DE-2024/41

Request to Provide Advice on SEARs

Development	Escarpment Resort Avondale - Concept Plan for Eco-Tourist Facility - Request to Provide Advice on the Secretary's Environmental Assessment Requirements (SEARS) - SSD 69465207
Location	Lot 101 DP 1247603, Lot 1 DP120957, Lot 1 DP 386238, Lot 1 DP 415430, Lot X DP 416731, Lot B DP 106828, Lot 1 DP 655151 Avondale Road AVONDALE NSW 2530

INDICATIVE MASTERPLAN AND ENVIRONMENTAL FACILITY PLAN

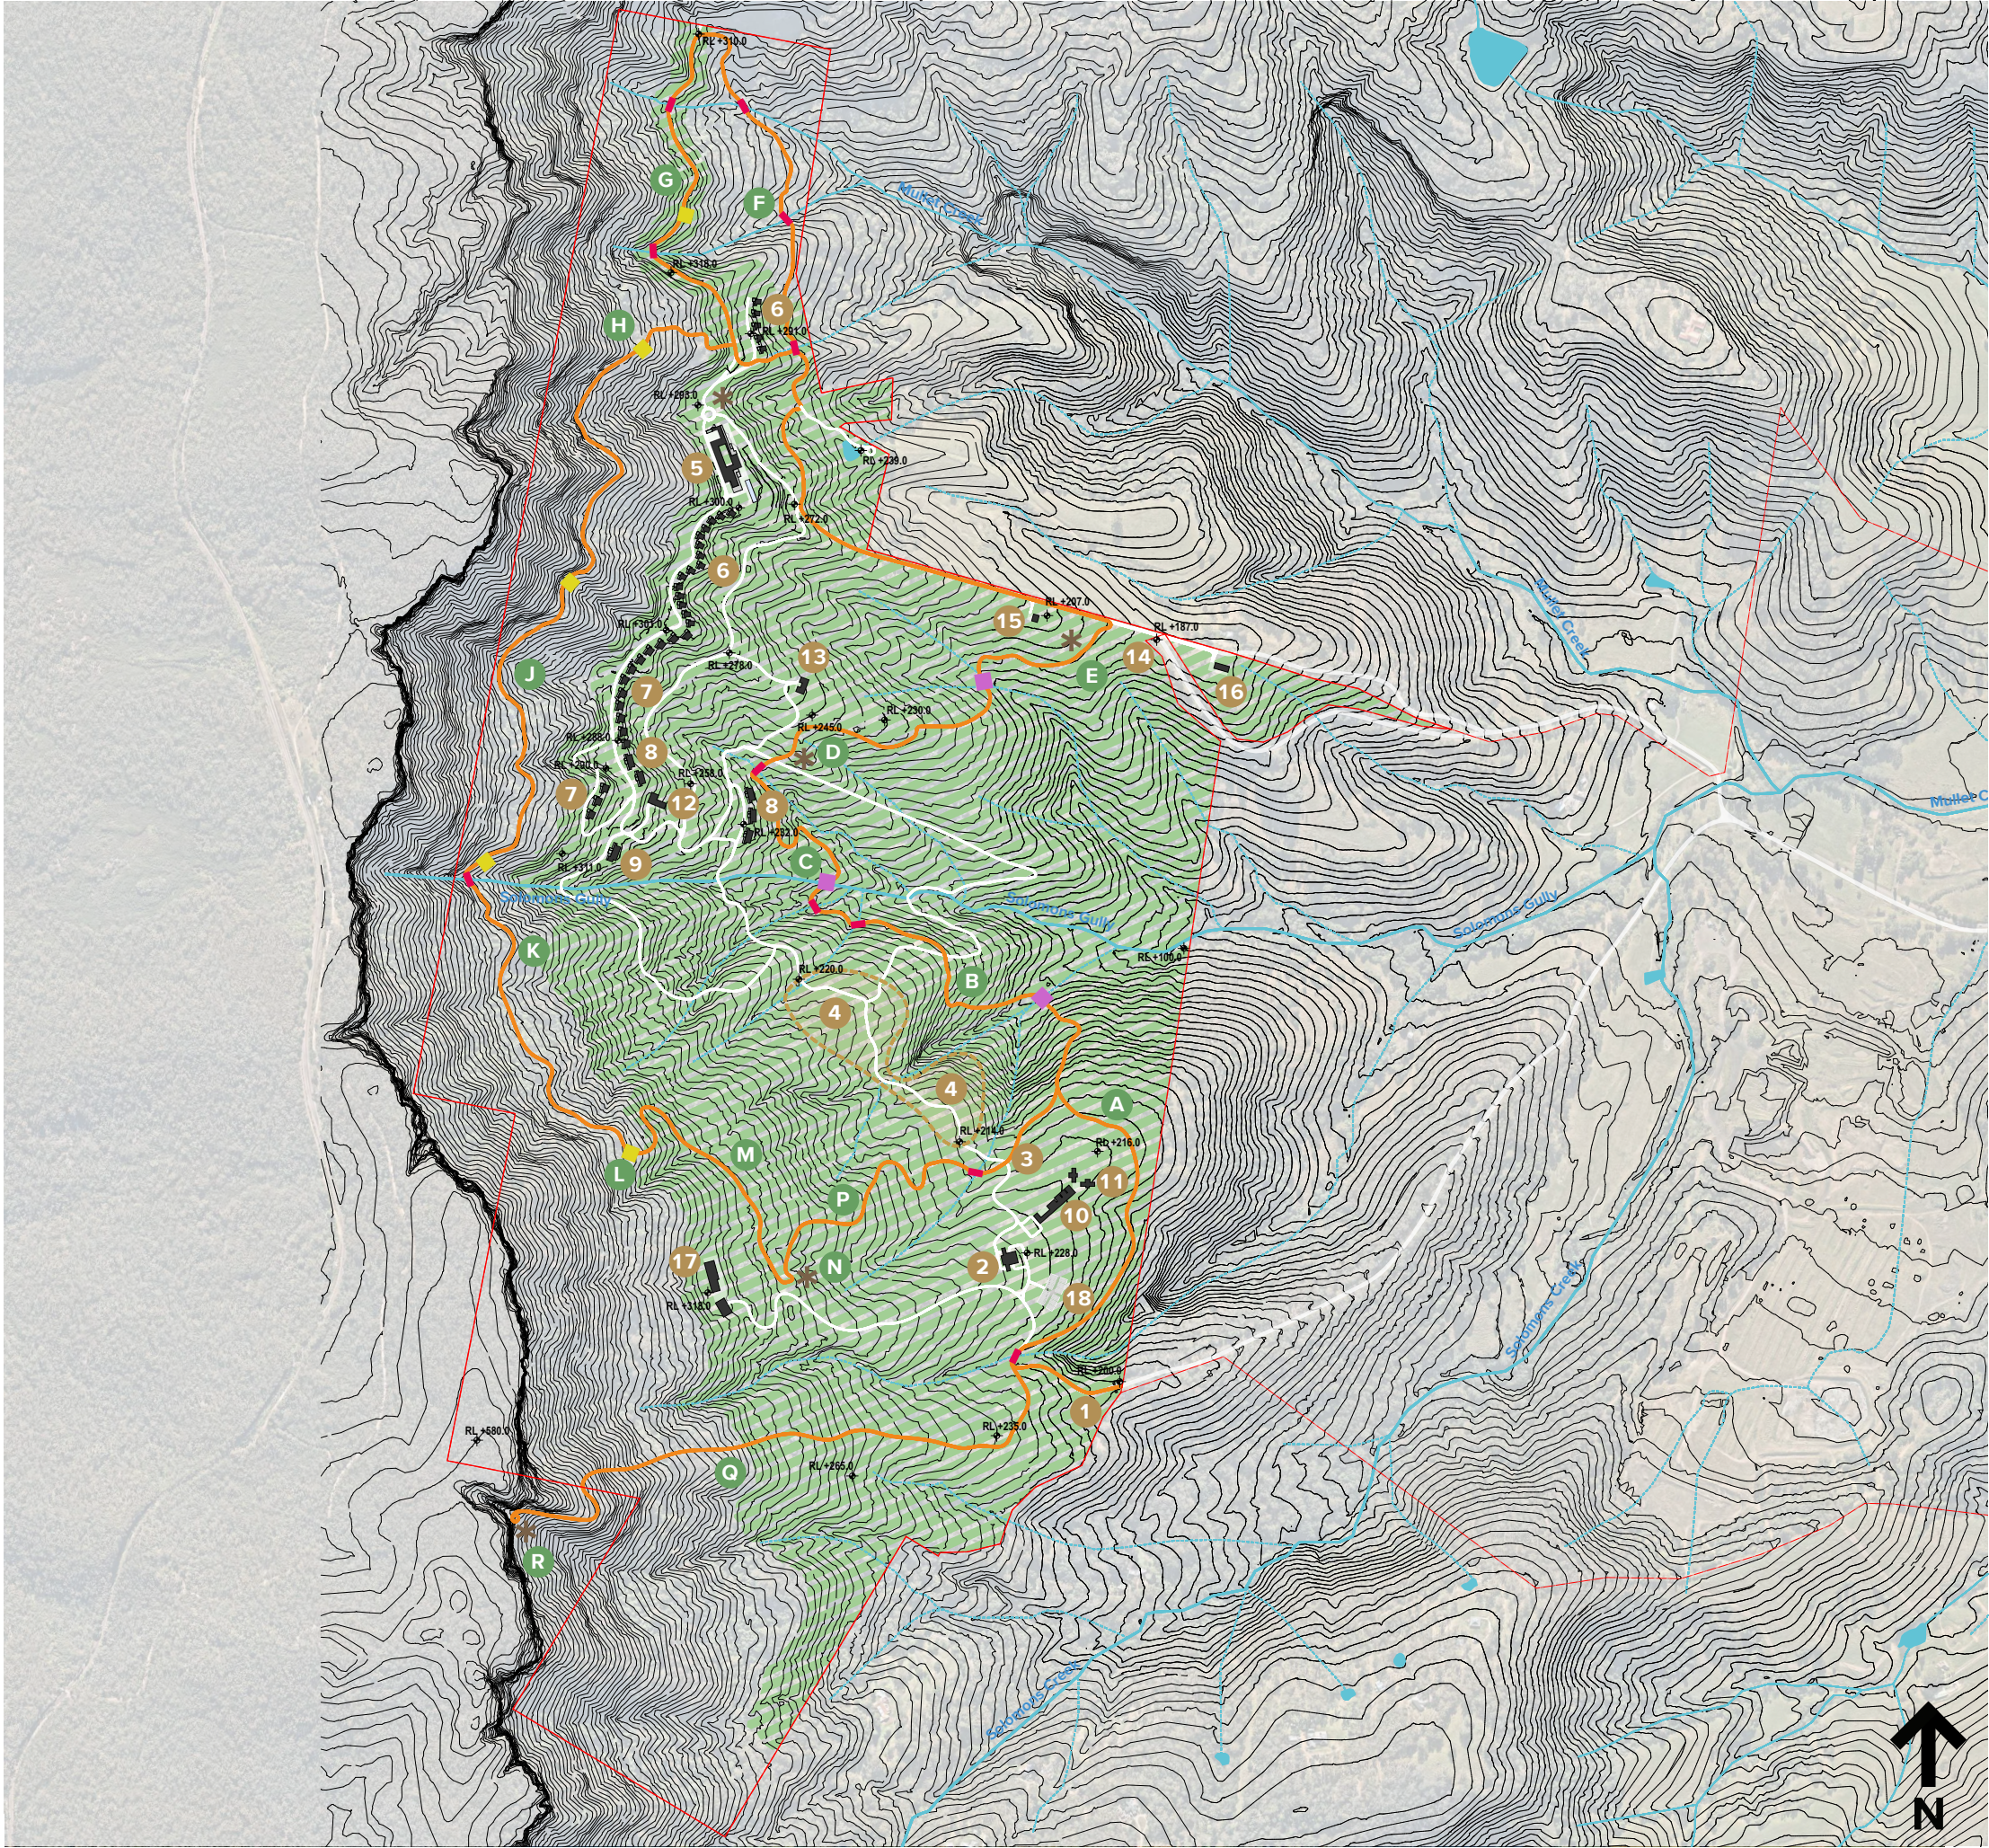
Figure 4 presents an indicative area for environmental protection works that is greater than 170 ha, and the indicative location of greater than 7 km of walking tracks, 11 footbridges, 5 lookouts and 3 picnic shelters. Based on an average 1.5m width for walking trails, the construction footprint for the recreation facilities is likely to be greater than 10,000 sqm
